# Consultee Comment for planning application 23/02098/OUT

<b>Application Number</b>	23/02098/OUT
<b>Location</b>	Begbroke Science Park Begbroke Hill Begbroke OX5 1PF
<b>Proposal</b>	<p>Outline application, with all matters reserved, for a multi-phased (severable), comprehensive residential-led mixed use development comprising: Up to 215,000 square metres gross external area of residential floorspace (or c.1,800 homes which depending on the housing mix could result in a higher or lower number of housing units) within Use Class C3/C4 and large houses of multiple occupation (Sui Generis); Supporting social infrastructure including secondary school/primary school(s) (Use Class F1); health, indoor sport and recreation, emergency and nursery facilities (Class E(d)-(f)). Supporting retail, leisure and community uses, including retail (Class E(a)), cafes and restaurants (Class E(b)), commercial and professional services (Class E(c)), a hotel (Use Class C1), local community uses (Class F2), and other local centre uses within a Sui Generis use including public houses, bars and drinking establishments (including with expanded food provision), hot food takeaways, venues for live music perform

Figure 2—1 Illustrative Masterplan

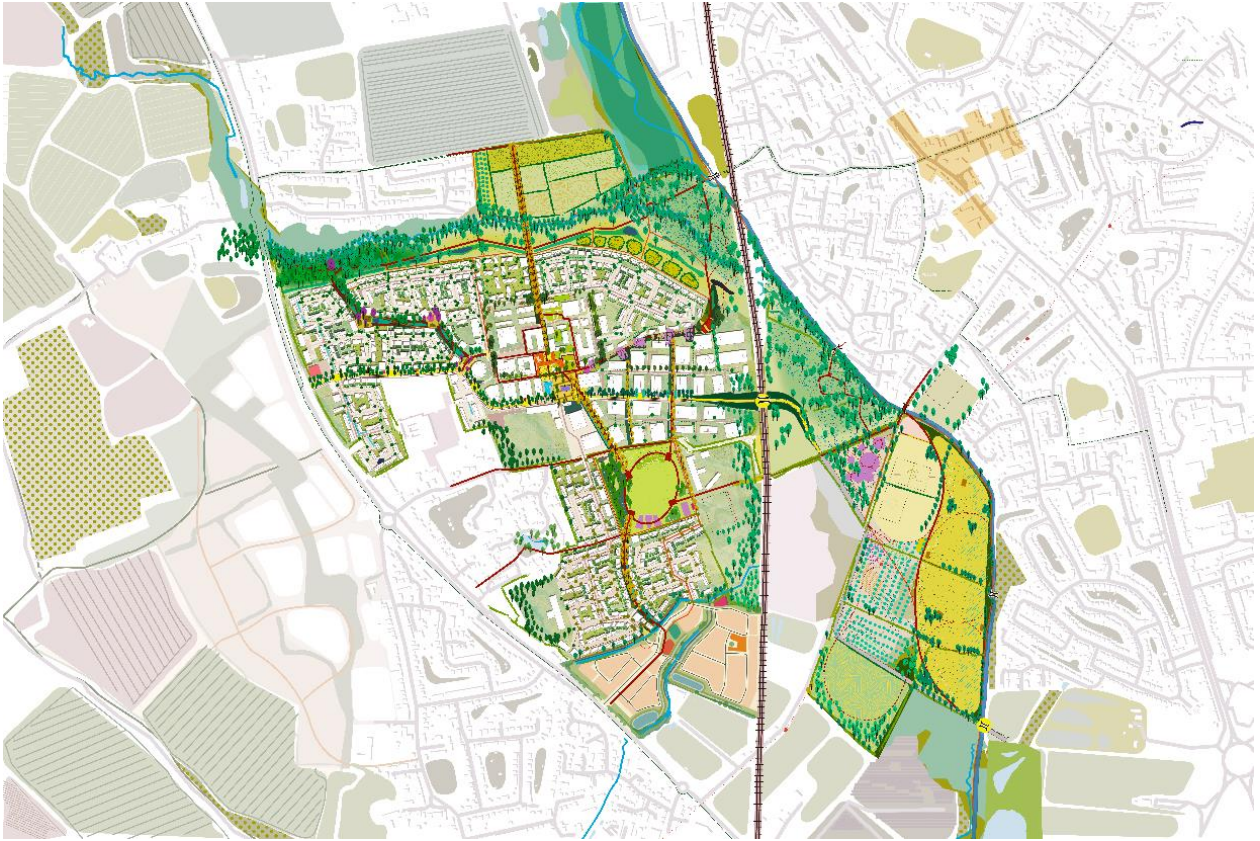
Flood Risk Assessment and Drainage Strategy Part 1) shows series of connected swales which is in accordance with the LLFA's policy of avoiding concentrated locations of attenuation. However, although indicative, the master-plan does not show clearly any maintenance corridors on each side of the linear series of swales. These will be required to be of minimum width 5 metres.
